# CITY OF ALBUQUERQUE

**RE: Lomas Town Homes  
Grading and Drainage Plan  
Engineer's Stamp Date 12-21-2016 (file: K22D057)**

Project Title: LOMAS TOWNHOMES Building Permit #: \_\_\_\_\_ City Drainage #: K22-D057

RE: Lomas Town Homes  
Grading and Drainage Plan  
Engineer's Stamp Date 12-6-2016 (file: K22D057)

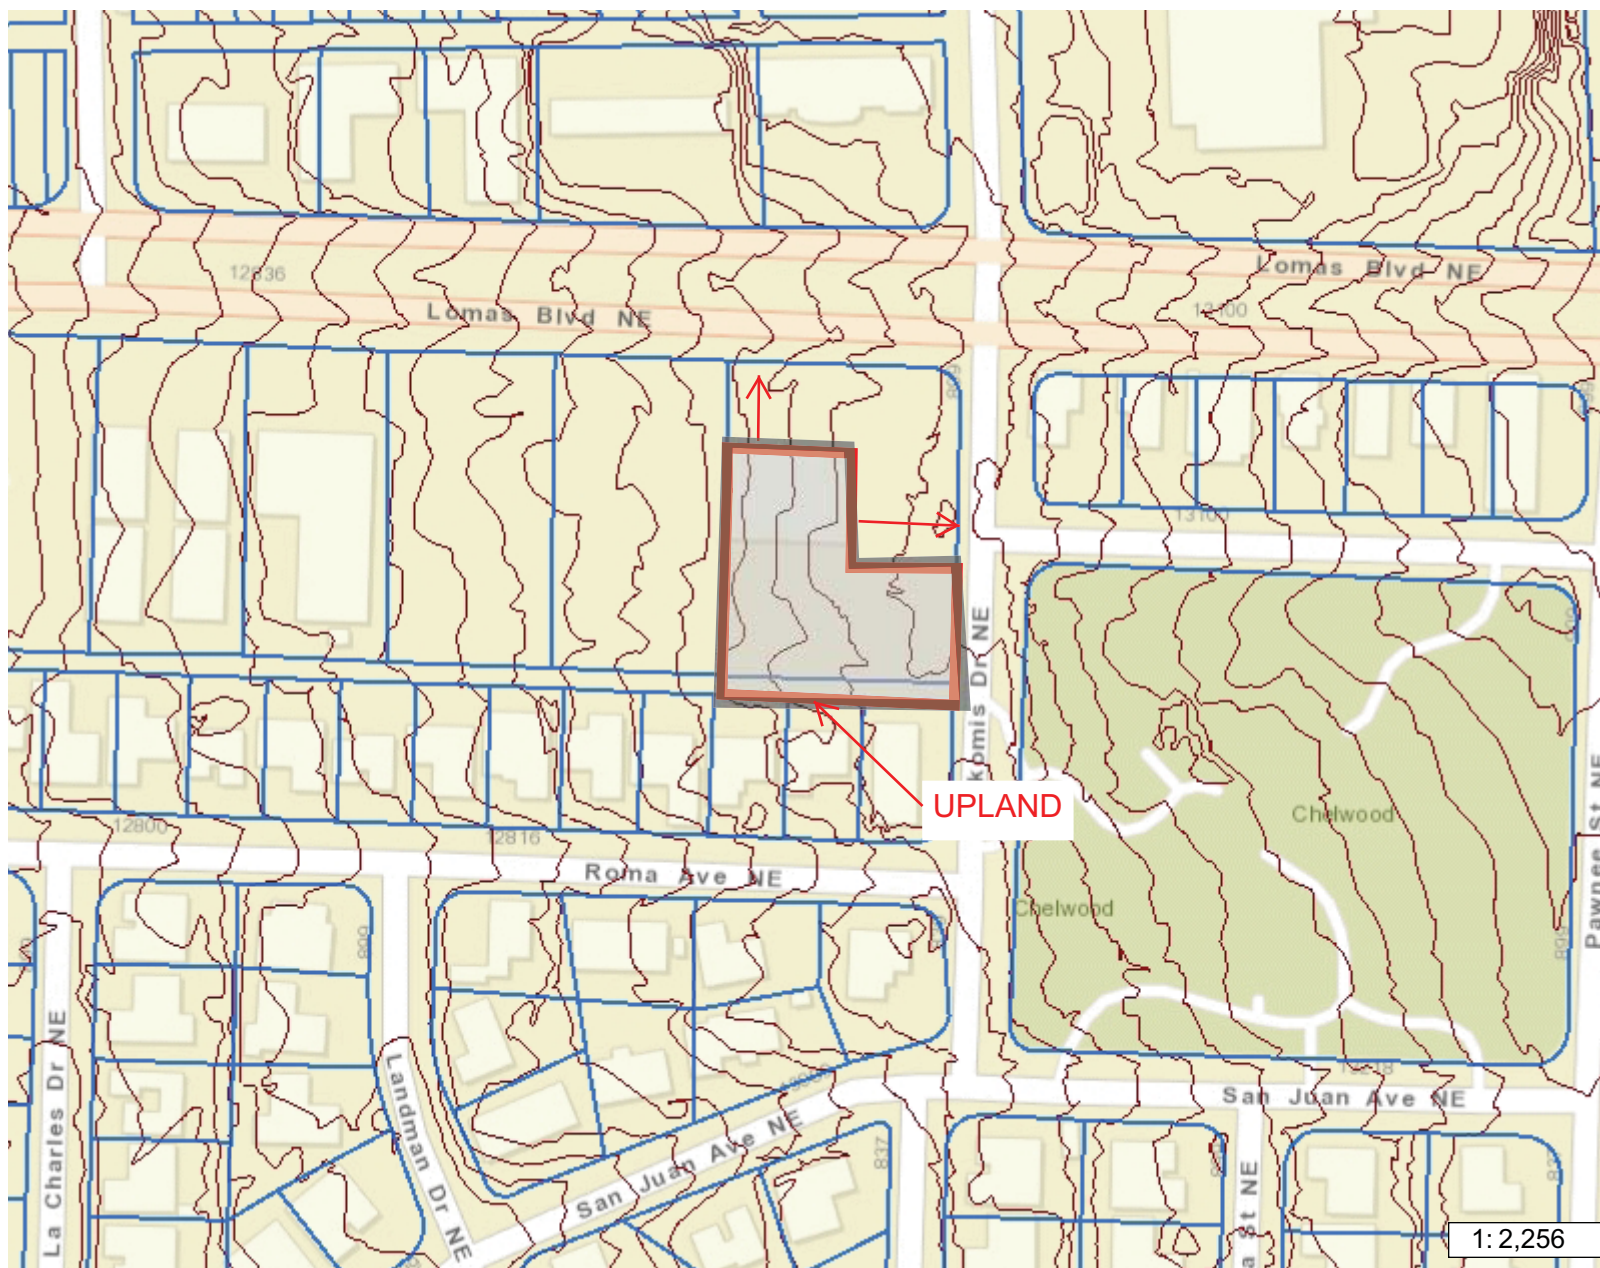
1. Provide a basin map for the offsite basin. Include calculations for flow and volume. It appears the swale in the southeast corner drains north. Shouldn't it drain south?
2. Provide the outfall location for the offsite basin. we have added map, calcs and outfall
3. The plan doesn't appear to provide storm water quality for basin C. we have added were practical
4. The pond in the northwest corner appears to have zero volume, pond bottom 99.5, culvert invert 99.5. we have modified to have 9" deep volume
5. Provide a build note for the curb cut in the parking island in the middle of the site. It seems a curb cut on the east side of parking island would also be beneficial. we have added
6. Please add that an excavation permit or work order is require for grading the alley. we have added
7. Please revise the water quality cobble swale detail to agree with the build note. we have revised
